From: Toolan Adrian [REDACTED]
Sent: 21 January 2015 12:40
To: Planning.Responses
Subject: Network Rail Consultation - FG/161/14/PL - FAO Ms A Gardner

Thank you very much for consulting with Network Rail in regards to planning application FG/161/14/PL. Please see related comments below;

Project Name and Address
Floor Plan & Elevations
New Storage Barn
Onslow Caravan Park
Ferring

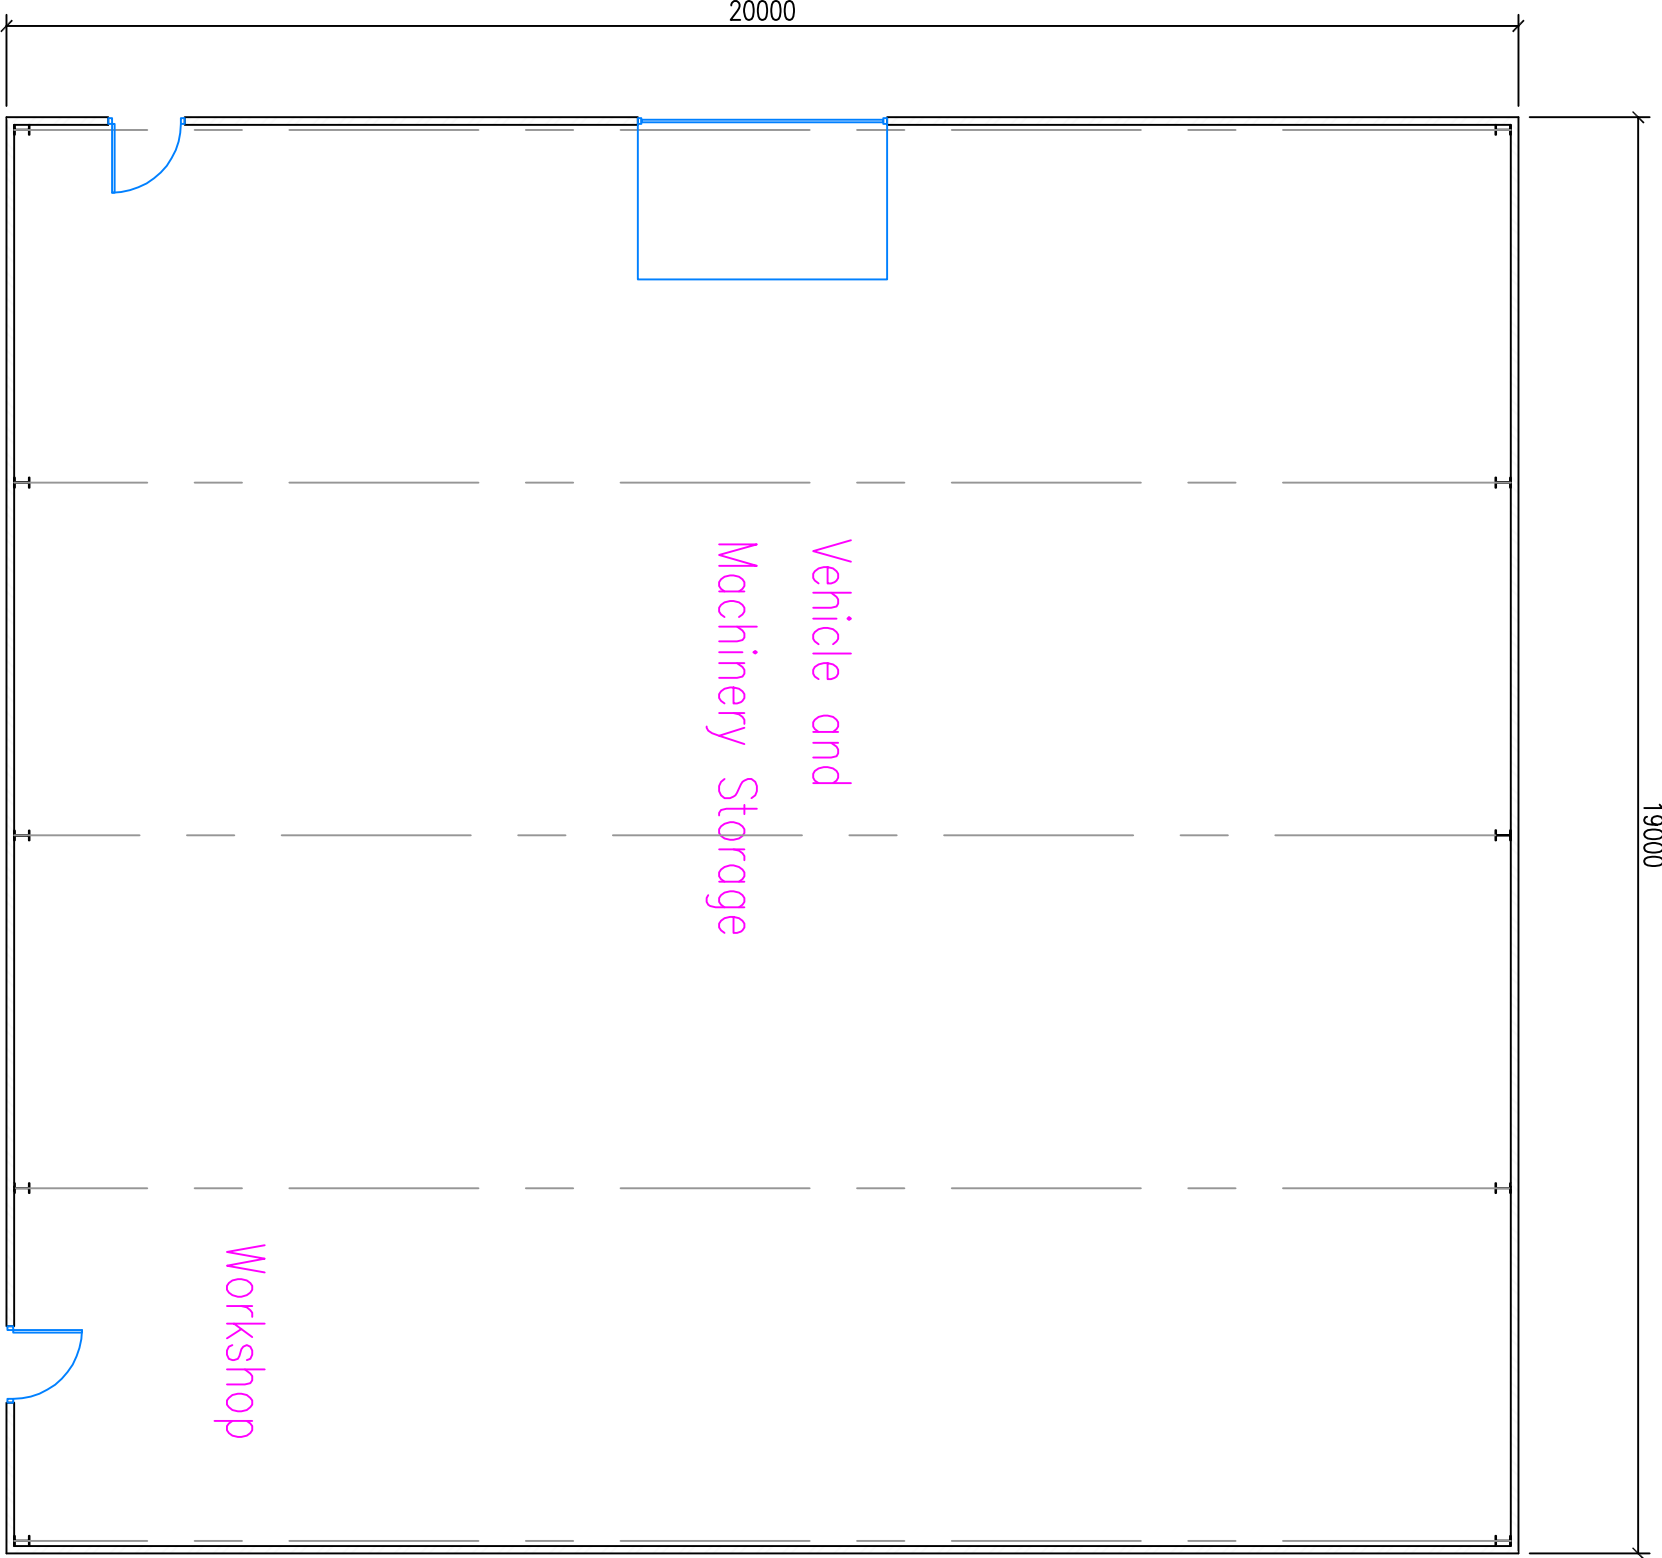
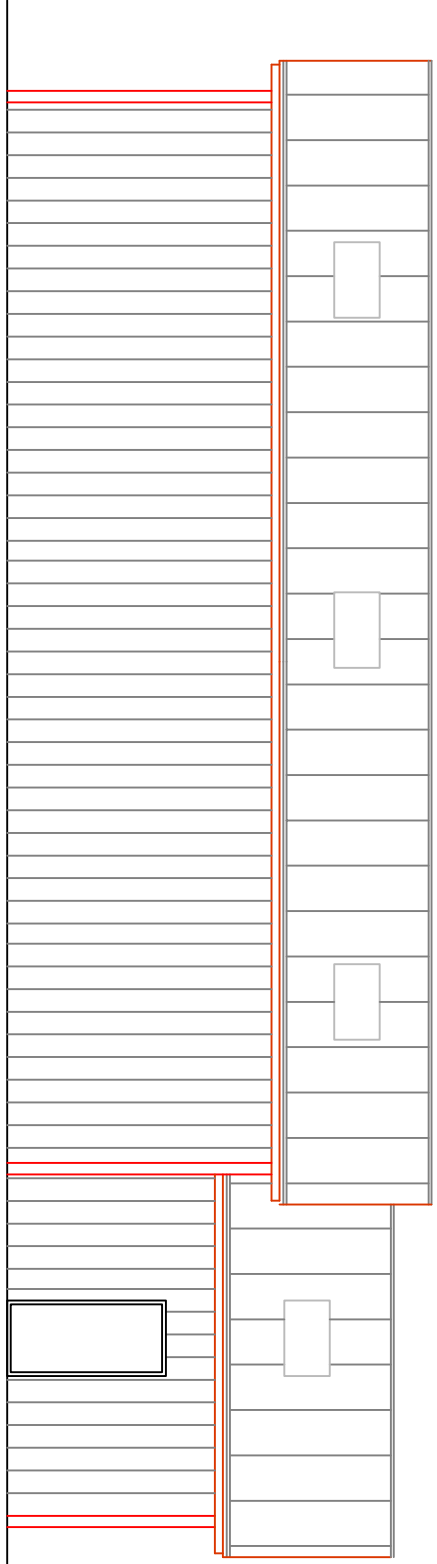
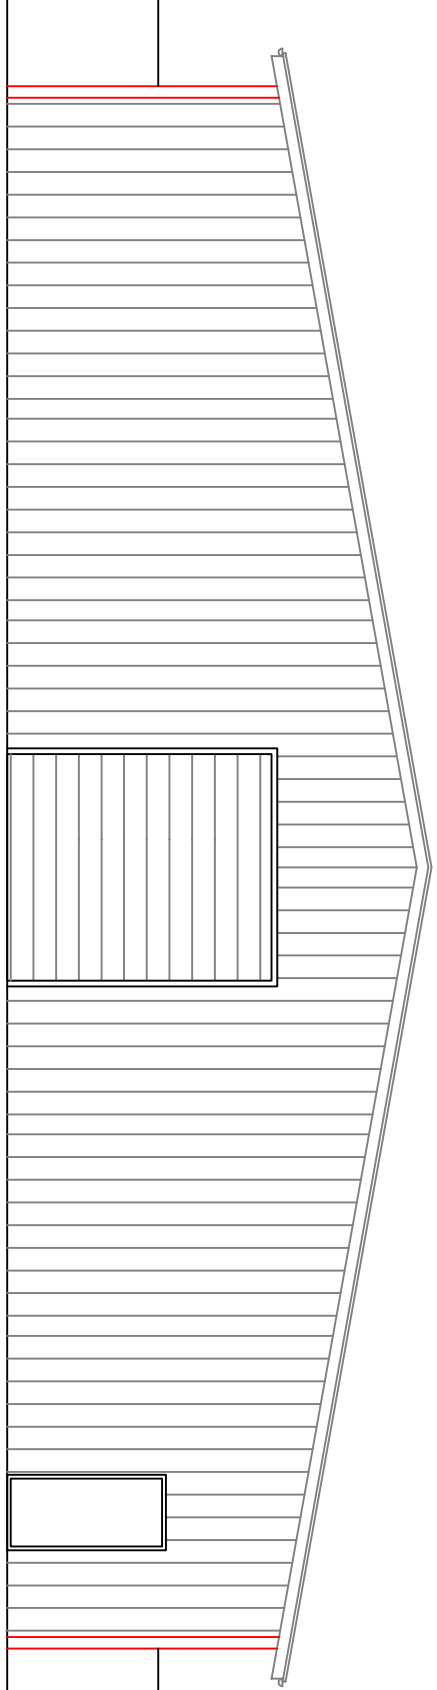
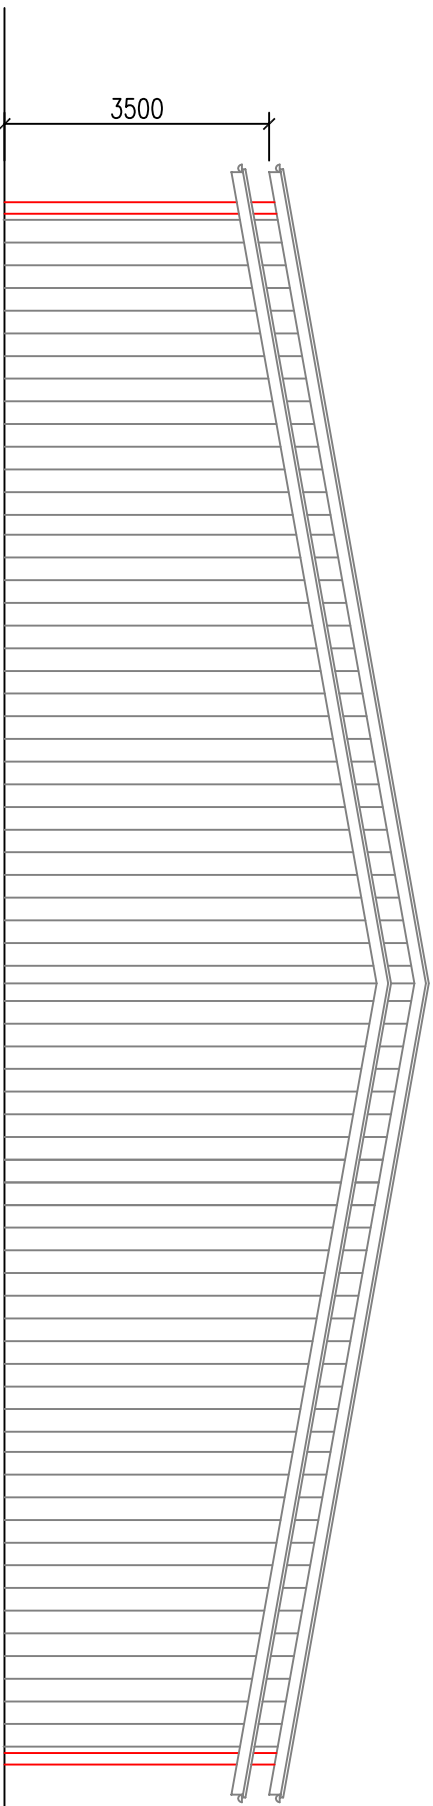
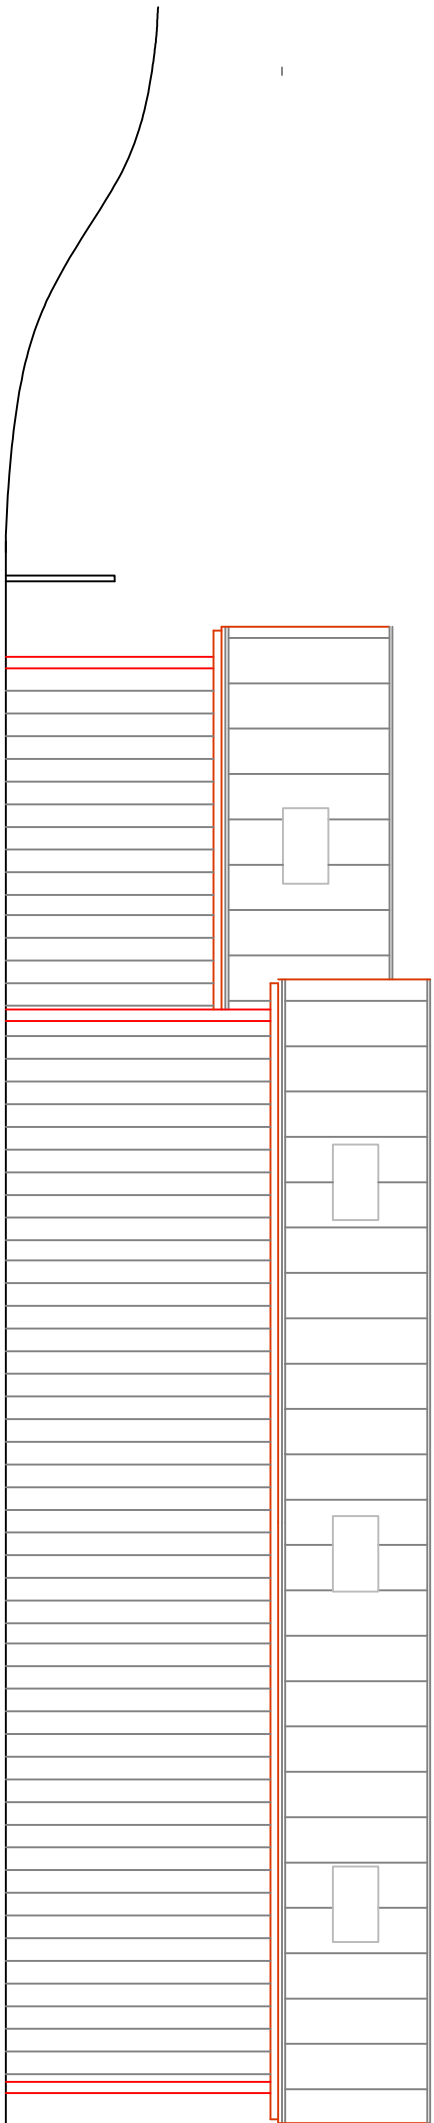
We note that on the plan the new building appears to be in very close proximity to the Network Rail boundary. We request that any building should be situated at least **2 metres** from Network Rail's boundary. More detail is given below together with other criteria the developer should take into account in both the design and construction and future maintenance such as scaffolding, piling, plant and materials, drainage, and fencing.

We also note that the new building is over the culvert that runs under the railway. We would recommend the developer ensures that there are no covenants or restrictions as to building over the culvert in that area.
